**Re: Ref no 7110857582: pre-connection enquiry - Subject to contract | Contract denied
450 unit housing development at Carrs Hill, Carrigaline Road, Douglas, Co Cork**

Irish Water has reviewed your pre-connection enquiry in relation to water and wastewater connections at Carrs Hill, Carrigaline Road, Douglas, co. Cork. Based upon the details you have provided with your pre-connection enquiry and on the capacity currently available as assessed by Irish Water, we wish to advise you that, subject to a valid connection agreement being put in place, your proposed connection to the Irish Water network can be facilitated.

Maria O'Dwyer
Connections and Developer Services

Drawing Title
PROPOSED FOUL AND SURFACE WATER DRAINAGE LAYOUT - OVERALL

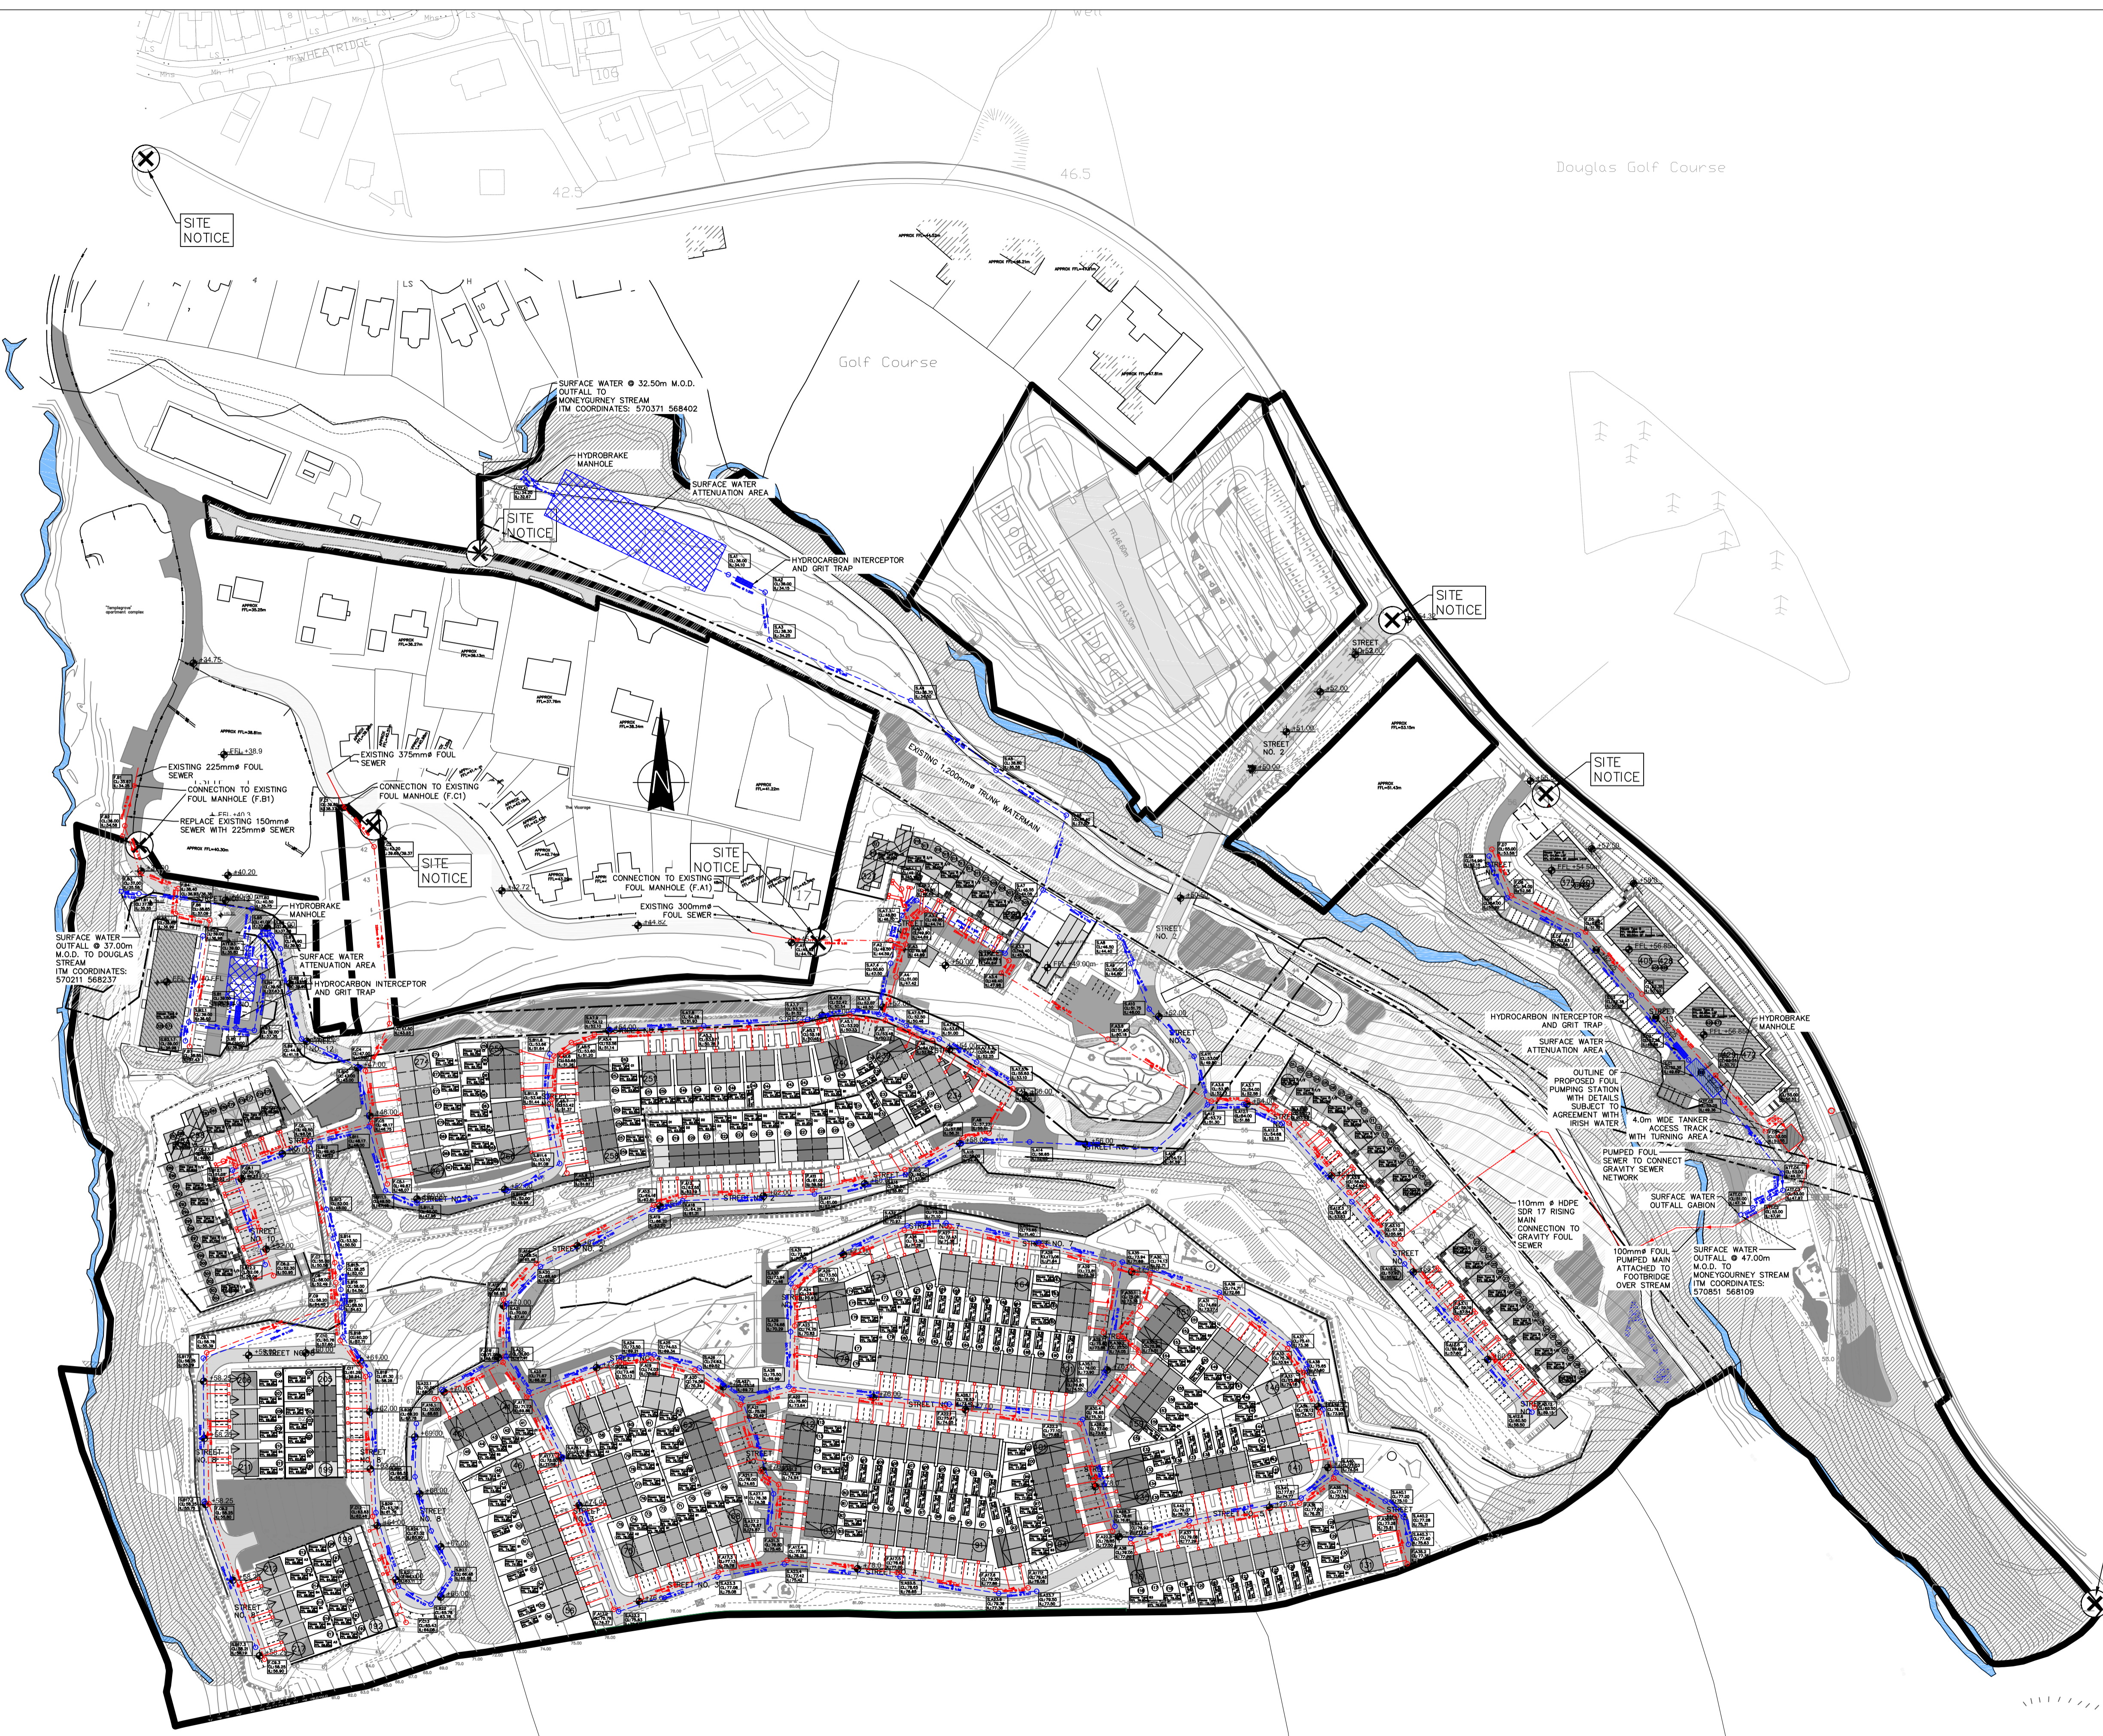
The proposed foul connection is a the network in the existing development into a manhole on the 300mm sewer to the North West of the site. This sewer connects to the 1200mm Tramore River Valley trunk further downstream. Due to the size of the development, a flow survey and CCTV survey of the 300mm sewer **is required** to confirm if there is sufficient capacity in the sewer to cater for the proposed development. Irish Water are currently carrying out a Drainage Area Plan (DAP) for Cork City. The DAP includes a CCTV survey of a section of the 300mm. There is no plan to carry out a flow survey of this sewer as part of the DAP. The DAP report is programmed for completion in Q1 2019. Irish Water can carry out a full flow survey of this sewer and CCTV of the section of Sewer that is omitted from the DAP. The costs of these surveys would be borne by the developer. Please contact me if you wish to proceed with these surveys.

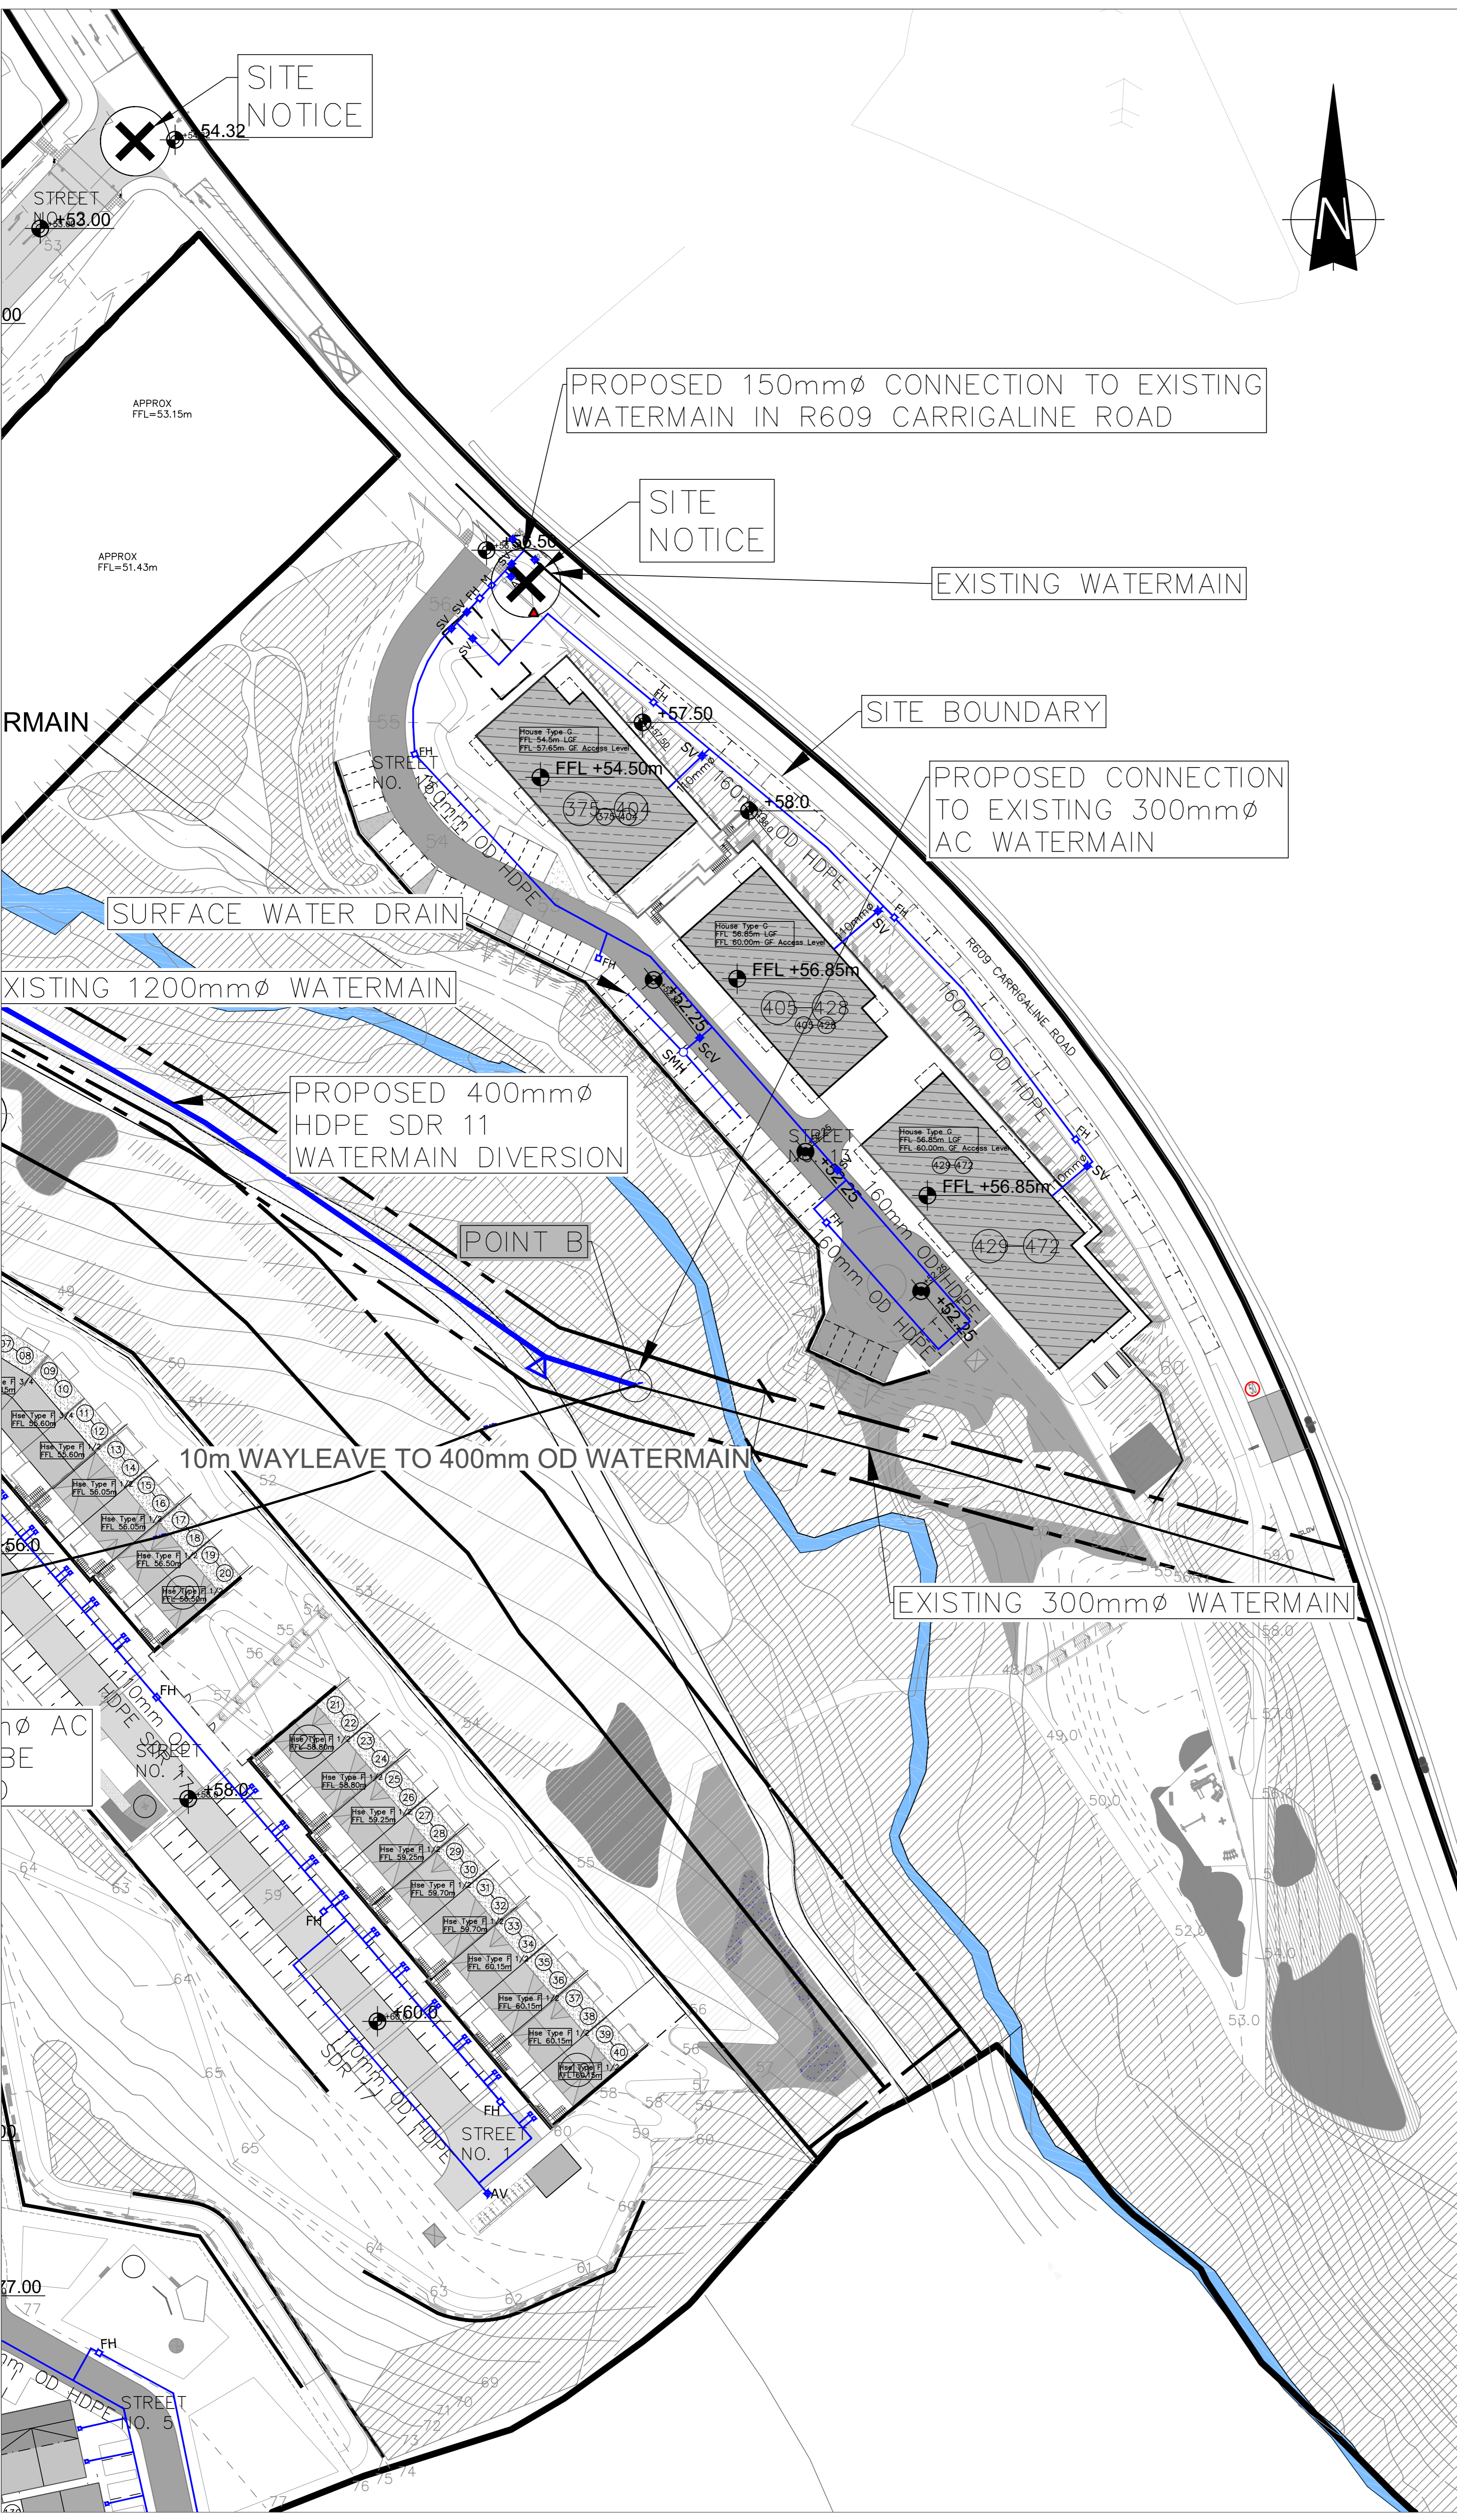
The proposed water connection is onto the 18" main on the N28 on the East of the site. Please note that there are currently 2 large diameter water mains passing through the proposed development. There is a 12" AC main and the 1200mm Cork Harbour & City main. The 1200mm is a critical water main supplying large industries in Ringaskiddy that cannot be shut off or diverted. Detailed design of the proposed development shall include detailed protection measures of this 1200mm main. Prior to any works beginning on site all protection measures of this mains must be submitted/agreed with Irish Water.
